From: Sue Howell
Sent: 04 April 2019 14:21
To: Planning.Responses
Cc: Simon Davis
Subject: FW: Planning Consultation on: Y/98/18/RES

Comment from Greenspace

APPLICATION Y/98/18/RES

Site Address: Land off Burndell Road Yapton

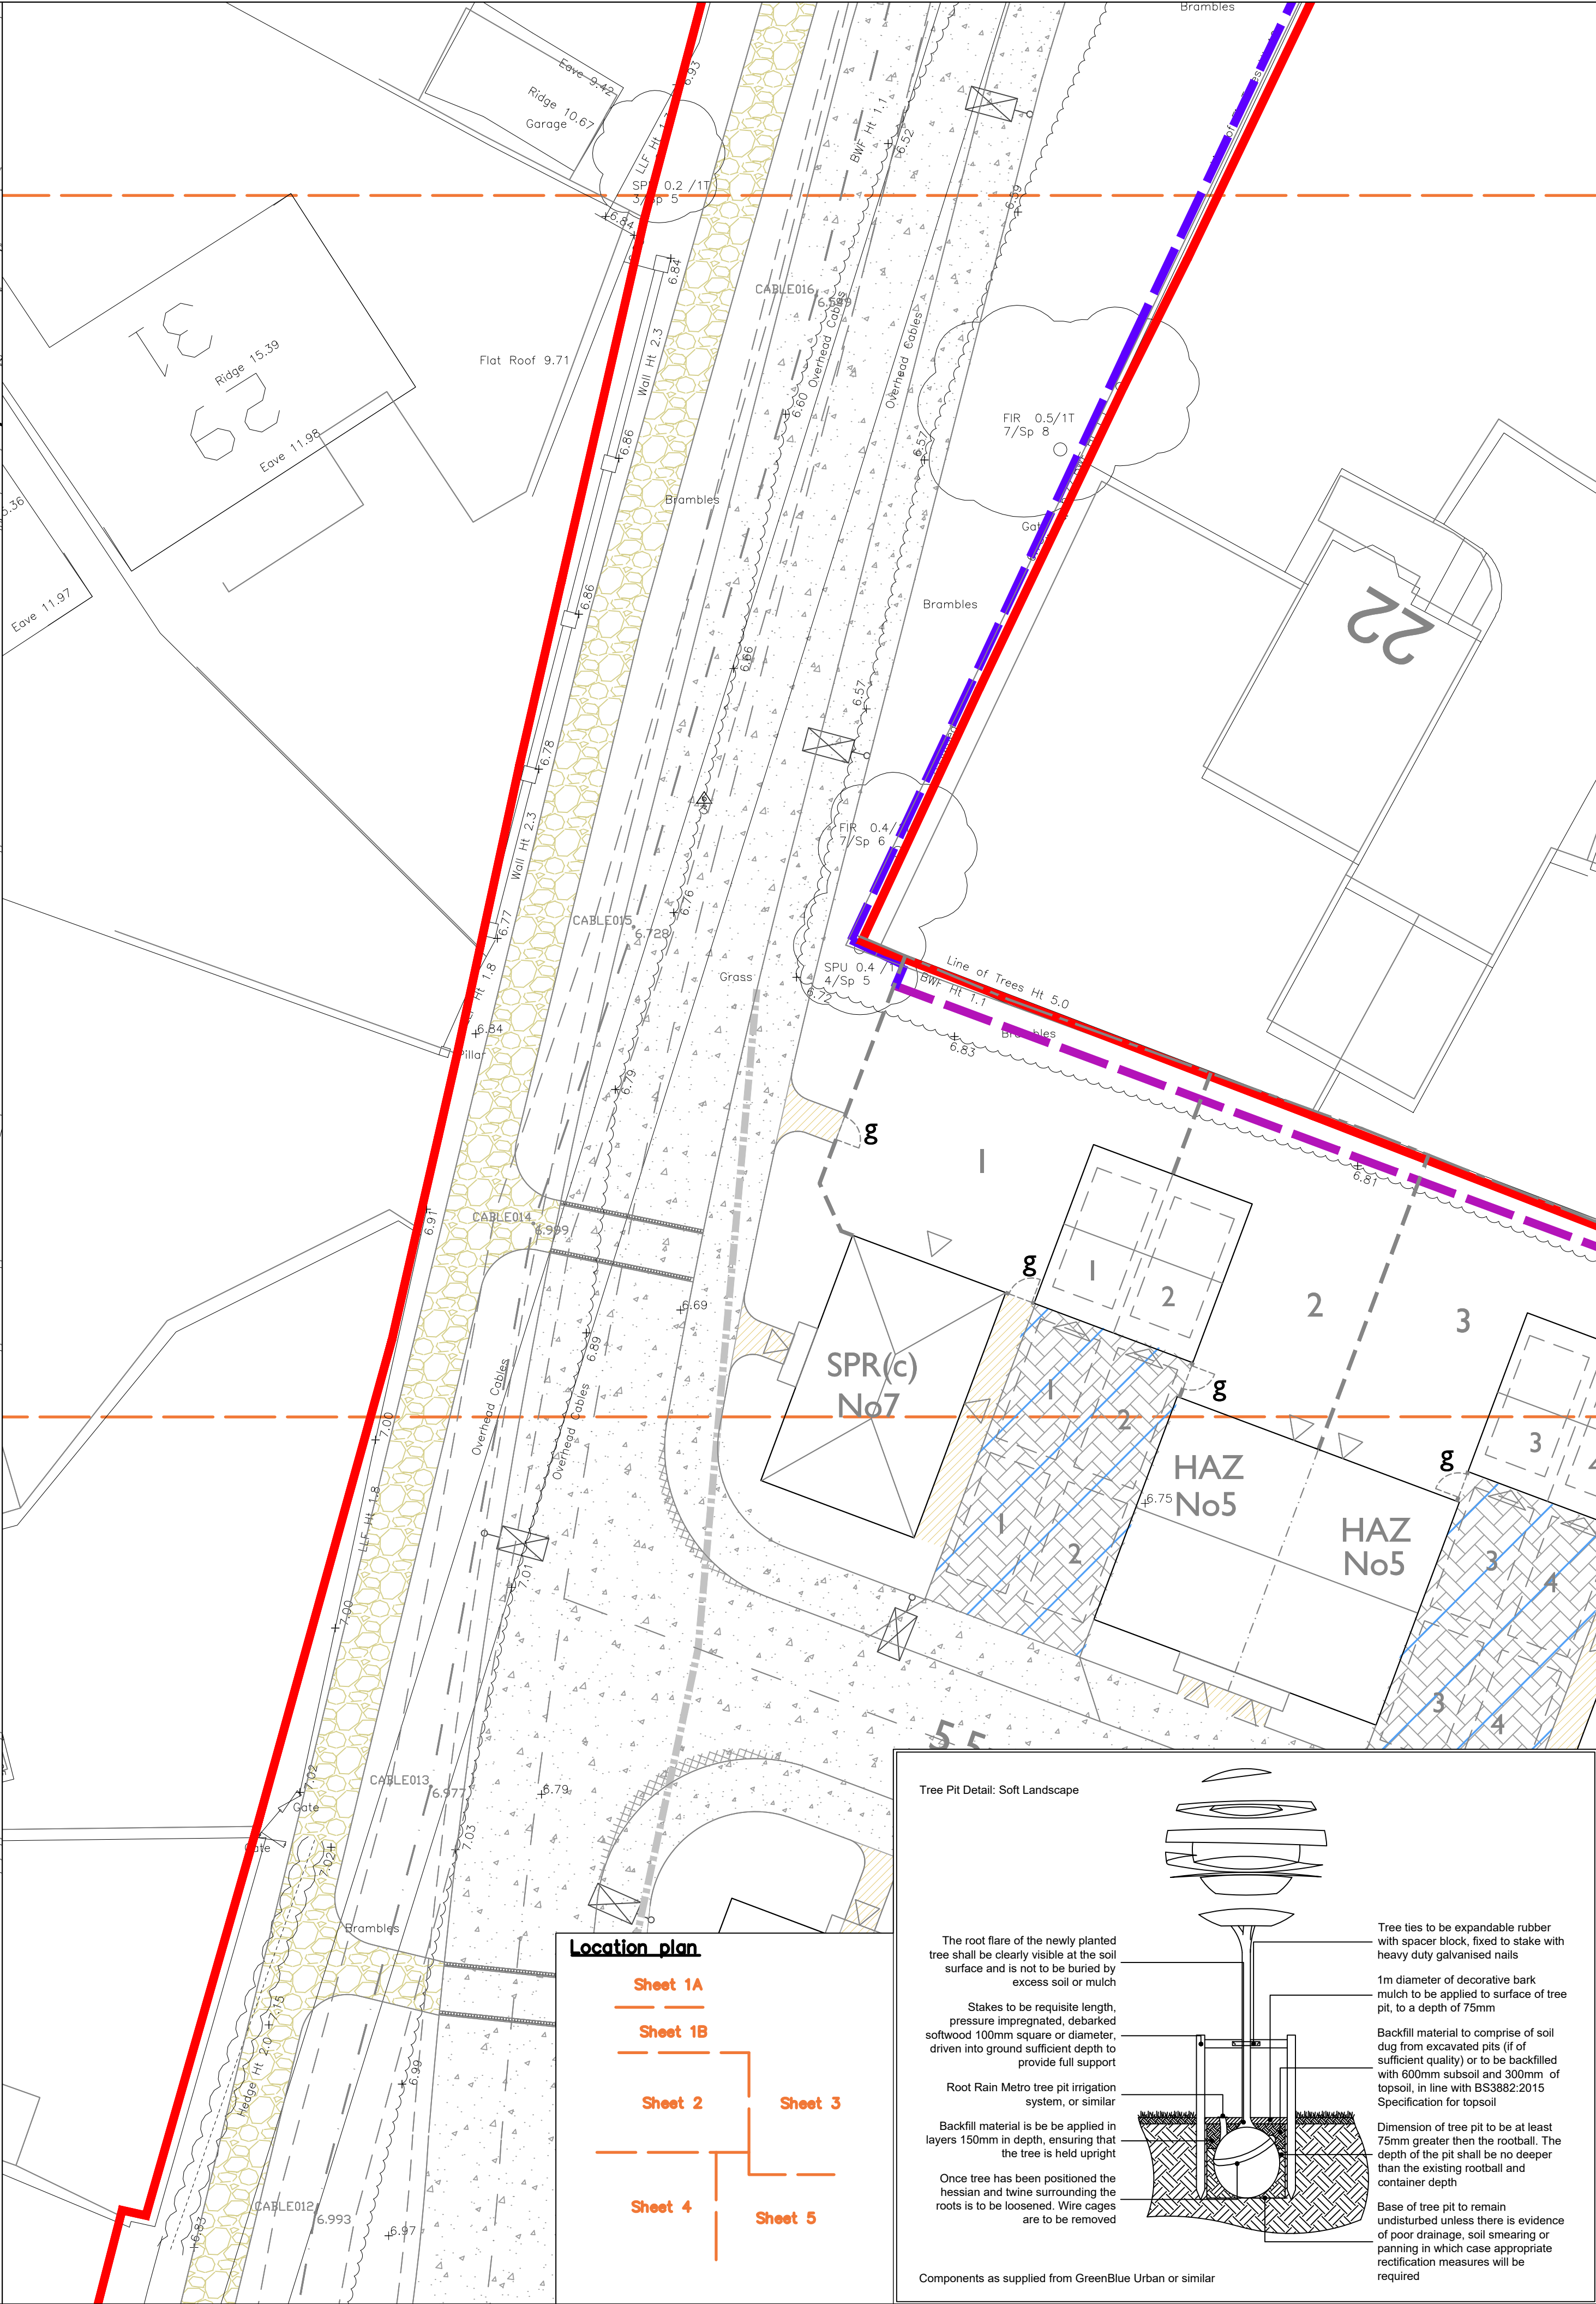
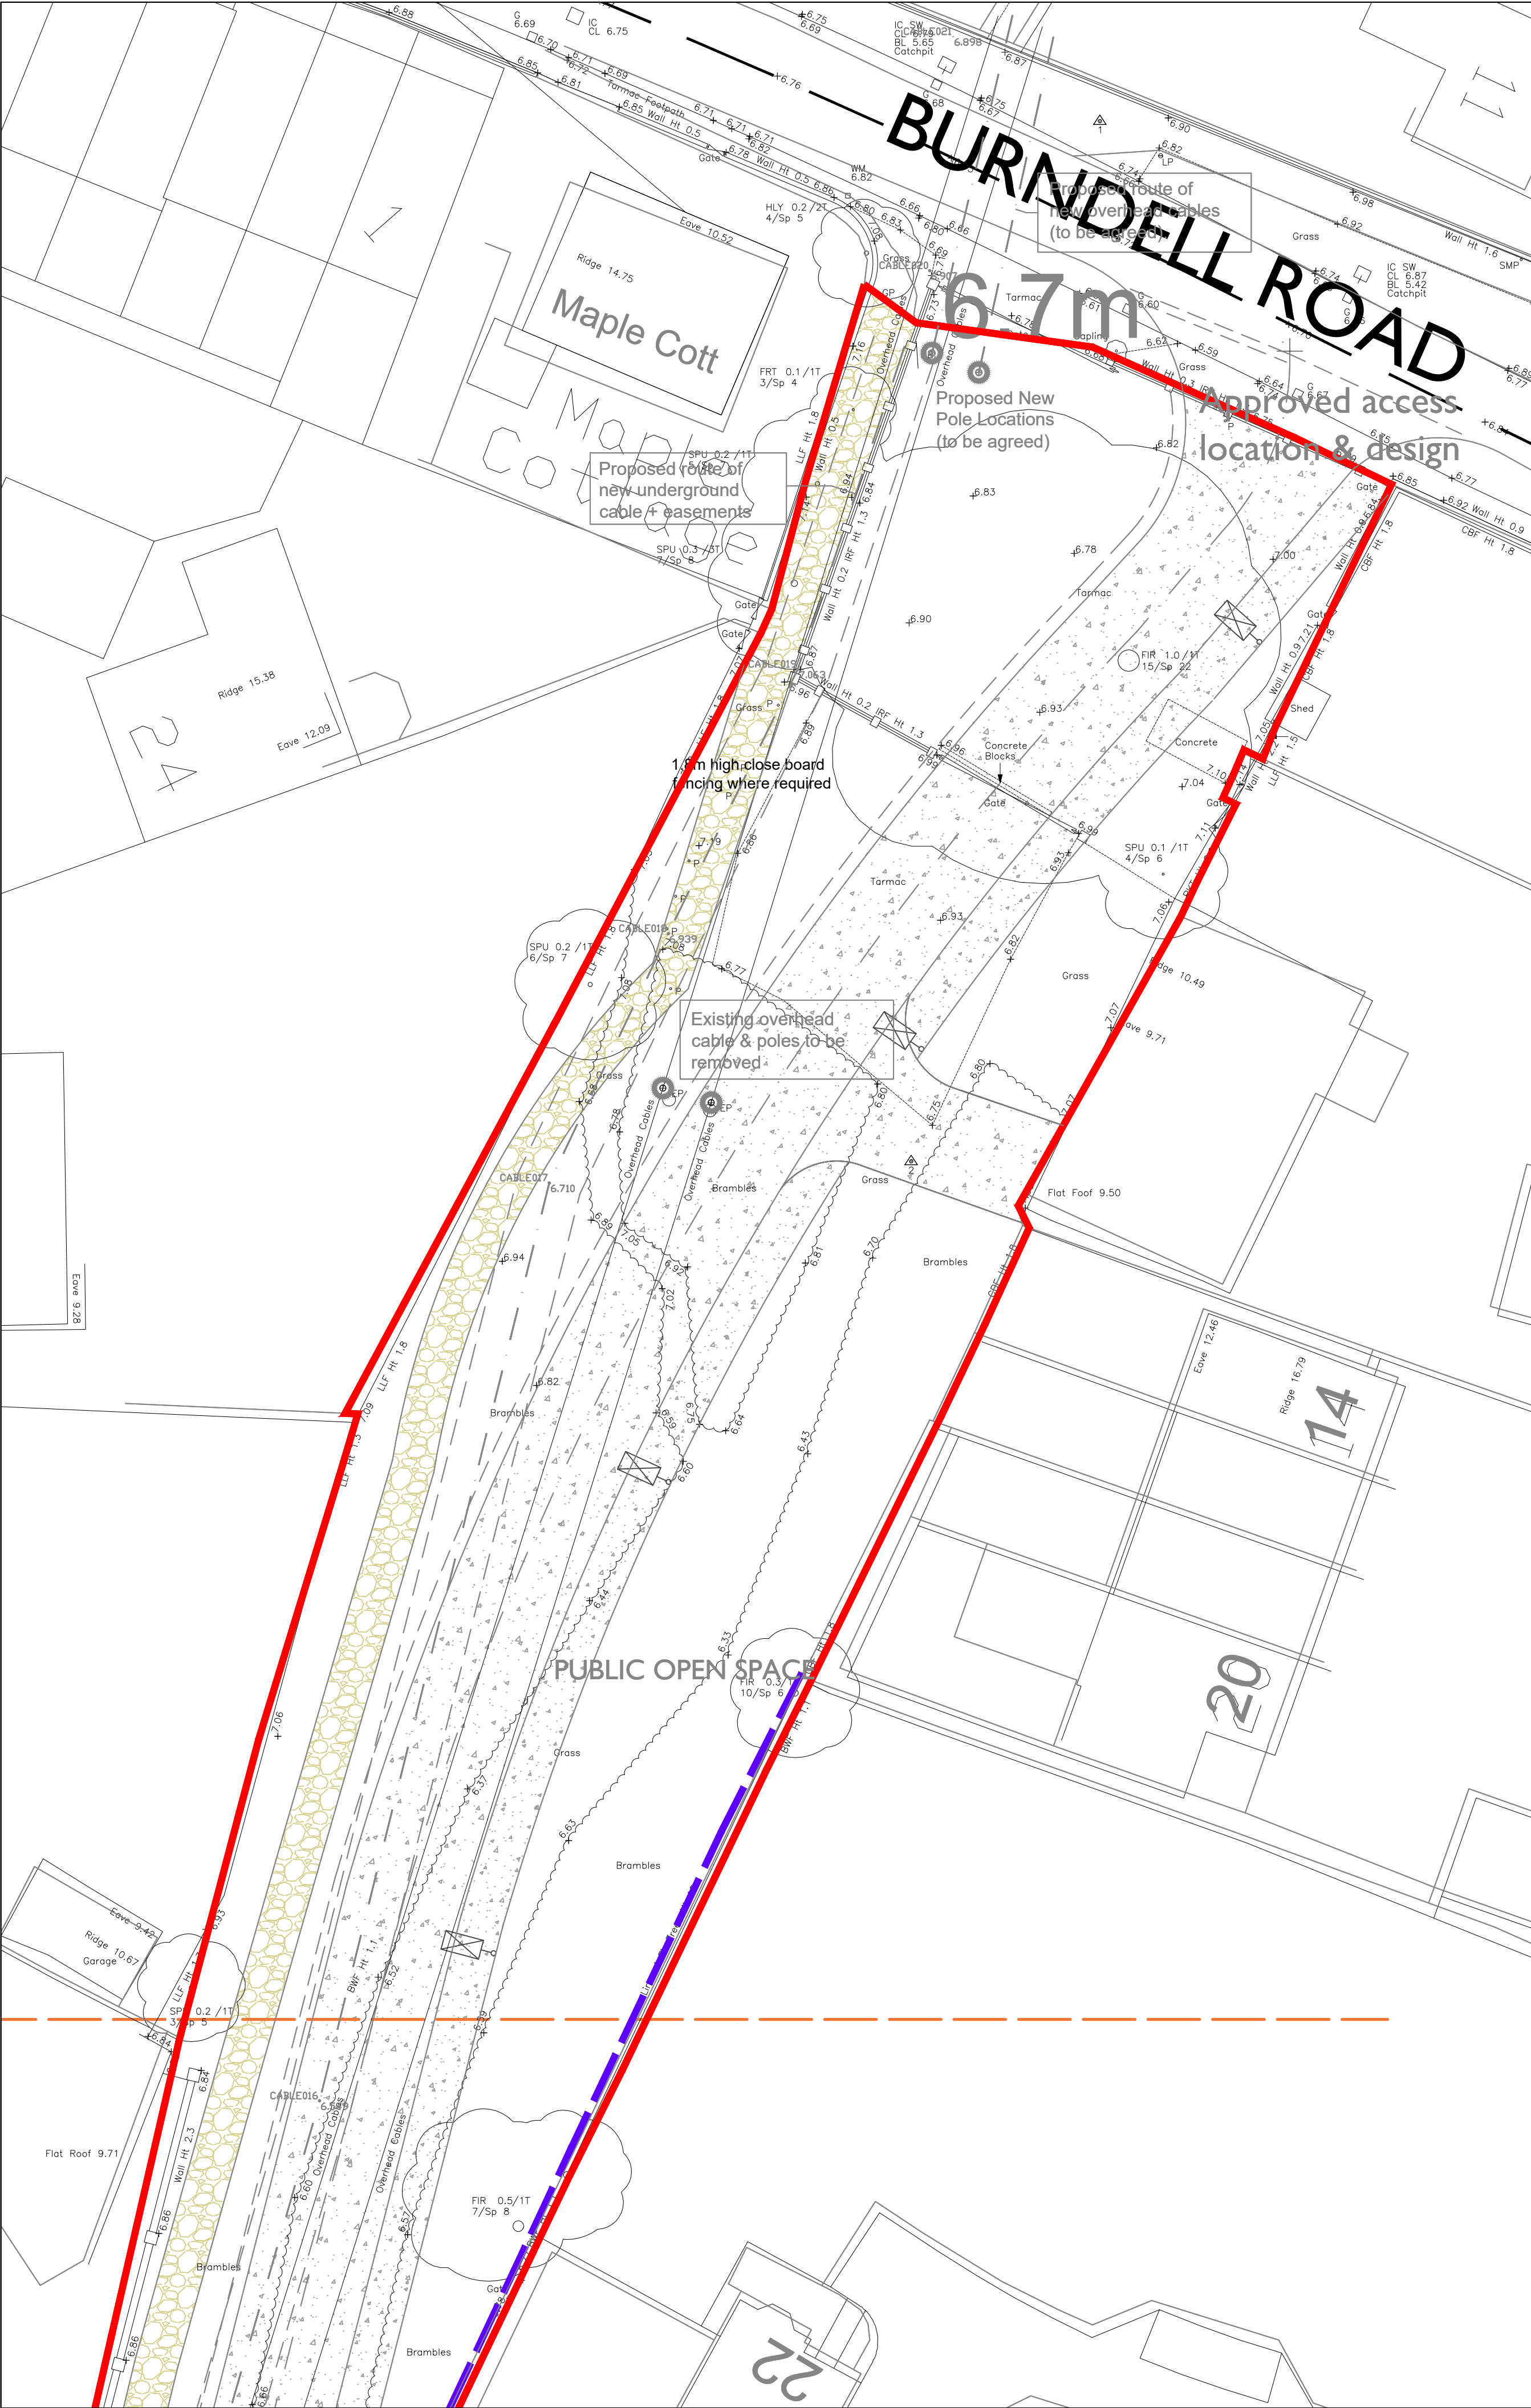
1. Further to submission of substitute landscape plans : Soft landscape Proposals Sheet 1 11E / Proposals 172 11E Sheet 2/3/4/5 the scheme proposed is sufficiently detailed providing a good mix of native and ornamental trees and shrubs, both deciduous and evergreen which will in time provide softening, provide increased amenity and add to the biodiversity of the development in this location.

3. I would still recommend that further clarification is provided regarding the boundary treatment between The Fellows Gardens development and the plots 1-16. The landscape plans indicate a boundary treatment of 1.2m high post and rail stock fence adjoining the 'to be retained existing hedgerow' the plan details this area as 'Existing hedge to be retained and **made good**' Please seek confirmation and the definition of proposals under '**made good**' treatment as there is no landscape detail for the gapping-up or any indication of additional planting shown for this area.
